From: Farhad Aarabi [REDACTED]
Sent: 20 August 2014 22:48
To: Janice Chapman
Subject: RE: Loft conversion with dormer at Flat 1, 33 Argyle Road, Bognor Regis

From: [REDACTED]
To: [REDACTED]
Subject: Loft conversion with dormer at Flat 1, 33 Argyle Road, Bognor Regis
Date: Wed, 20 Aug 2014 12:15:13 +0000

PROJECT	Proposed Loft Conversion		
	33 A Ayley Road, Bognor Regis, West Sussex		
TITLE	Proposed Elevations		
CLIENT	Mr Mohammed Abdul Majid		
SCALE	1: 100	DATE	28/06/2014
DRAWING NO.	134 - 03	REV.

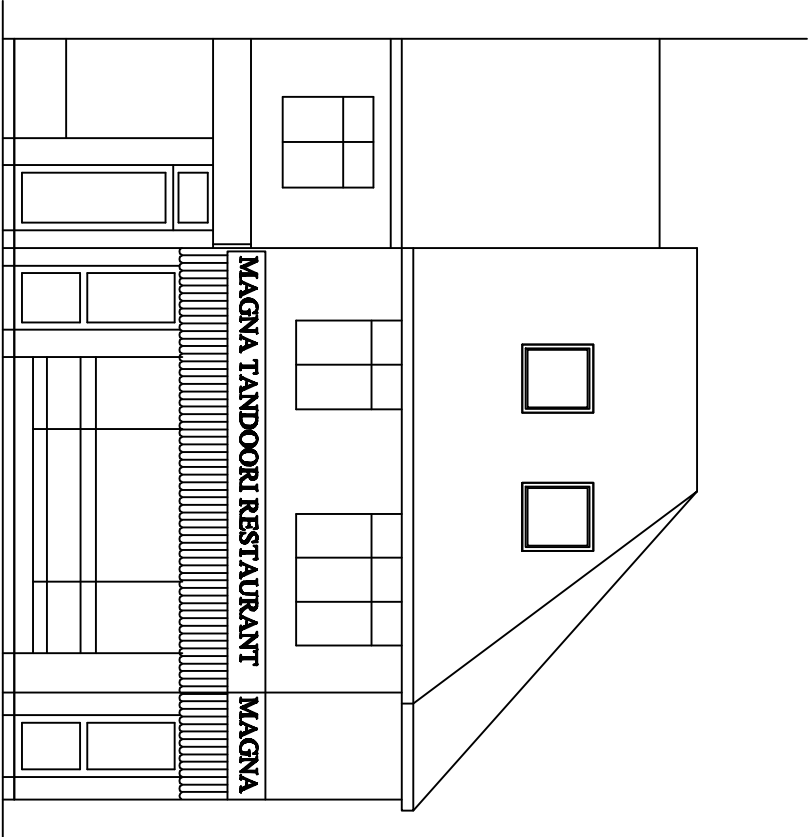
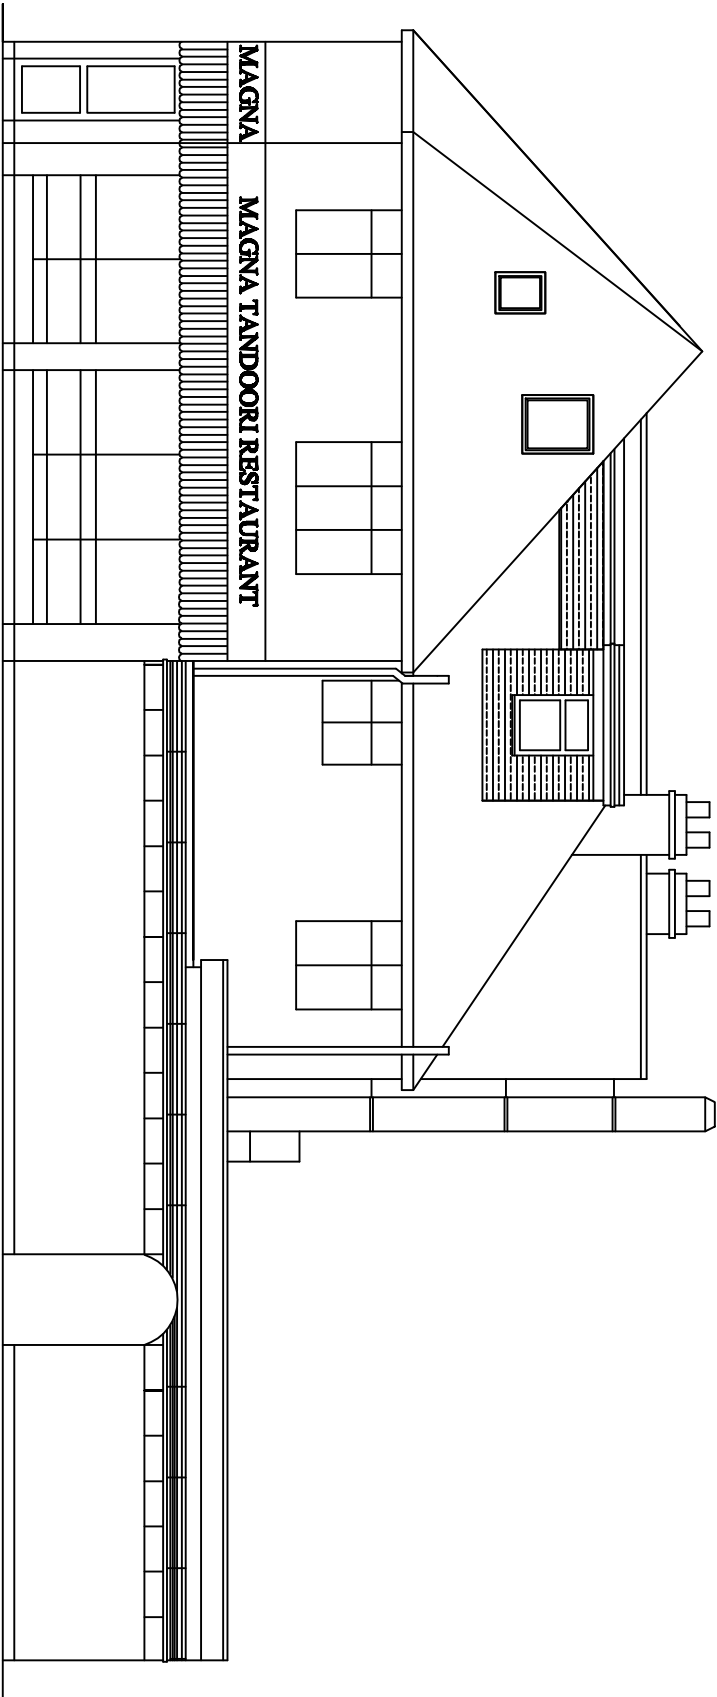
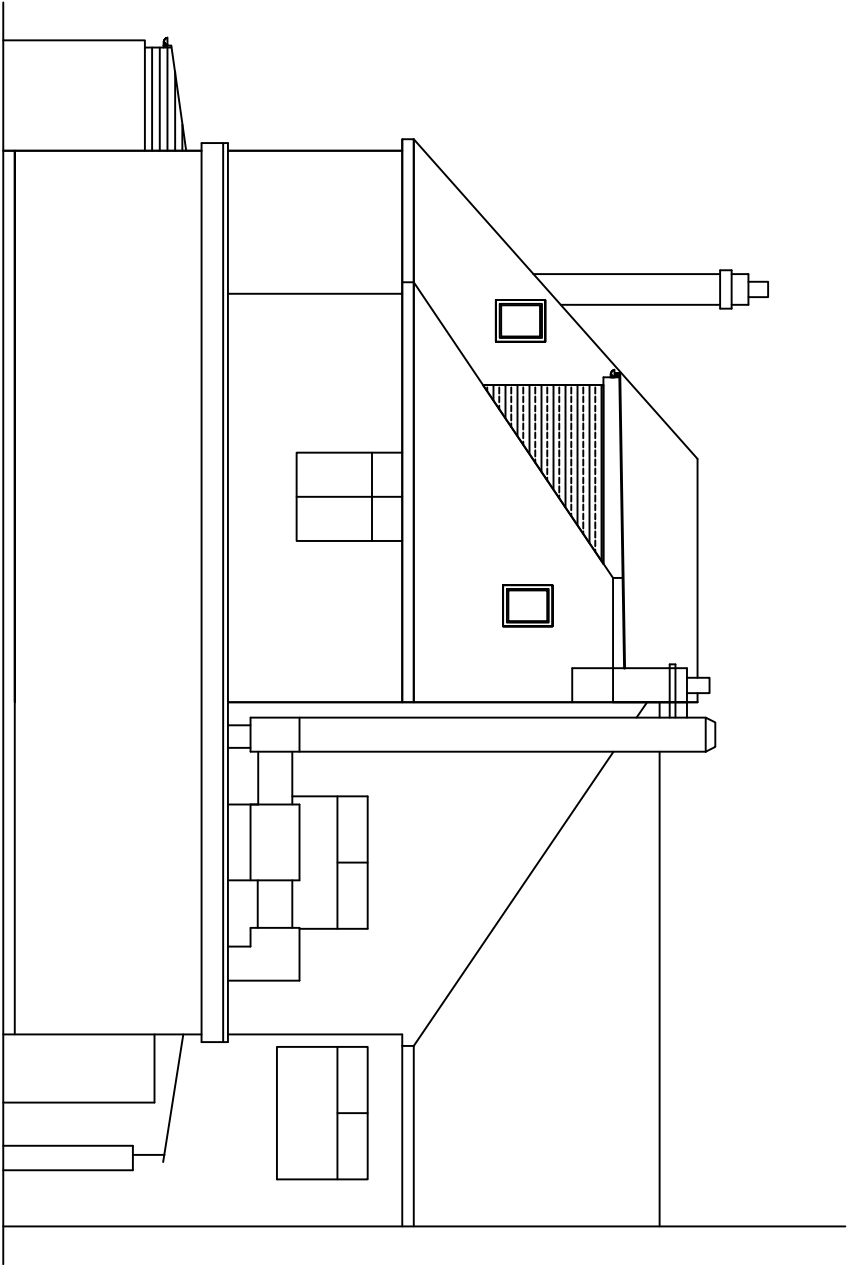
Please can you confirm the materials to be used for the cheeks of the dormer, is it slate to match the roof.

I am writing to confirm that the material used for the cheek of the dormer will be slate to match existing roof covering.
